Your ref:	7-9 Paddington Street Adverti...	<b>Please reply to:</b>	<b>Mr Gregor Gault</b>
Our ref:	24/00162/ADV	Tel No:	
		Fee Queries:	0207 641 6500;
		Email:	planningreception@westminster.gov.uk;
Matt Richards Savills 33 Margaret Street London W1G0JD United Kingdom		<b>Incomplete Applications</b> Town Planning & Building Control City of Westminster PO Box 732 Redhill, RH1 9FL	
		16 January 2024

**Address: 7-9 Paddington Street, London, W1U 5QH,**

**Proposal: Display of an externally illuminated fascia sign measuring 14.5cm x 63.5cm.**

CLIENT			
PROJECT MAMIE			
SITE ADDRESS 7 PADDINGTON STREET LONDON W1U 5QE			
TITLE PROPOSED SHOPFRONT A			
STATUS PLANNING APPLICATION			
SCALE 1:25	DATE 03.02.23	DRAWN AD	CHECK LC
PROJECT NO. 1432	DRAWING NO. 202	REVISION G

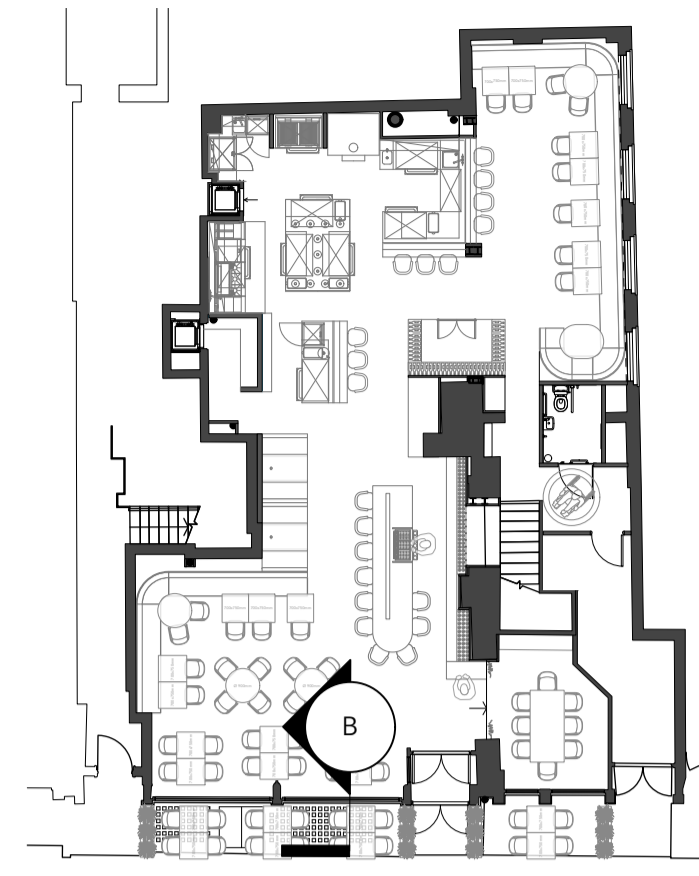
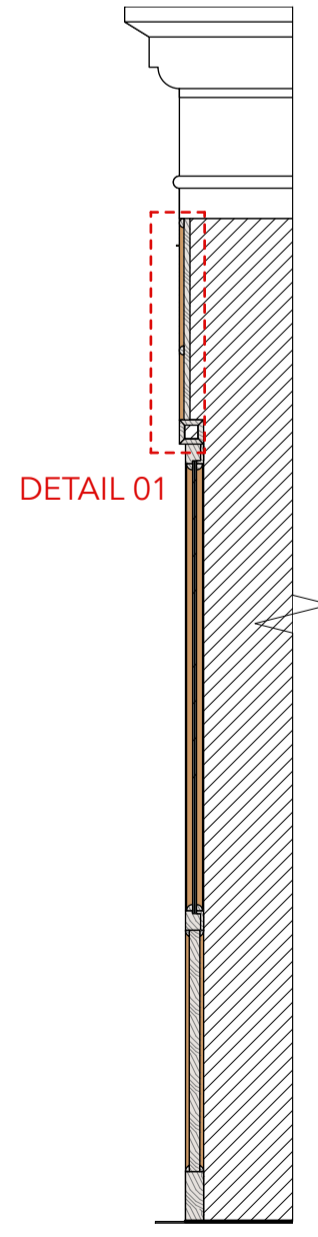
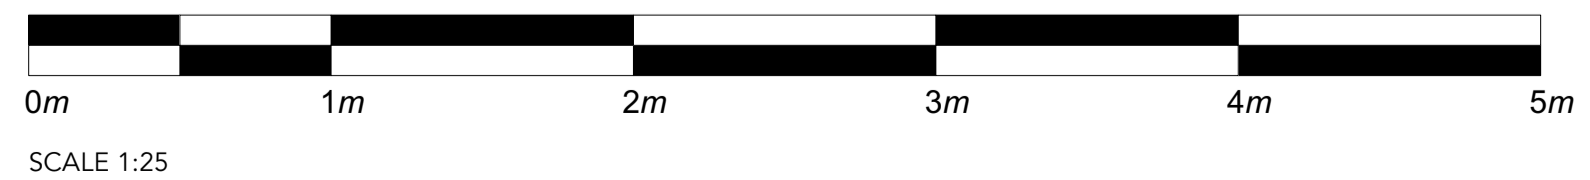
- existing and proposed sections through the shopfront to show the external illumination.
- existing elevations.
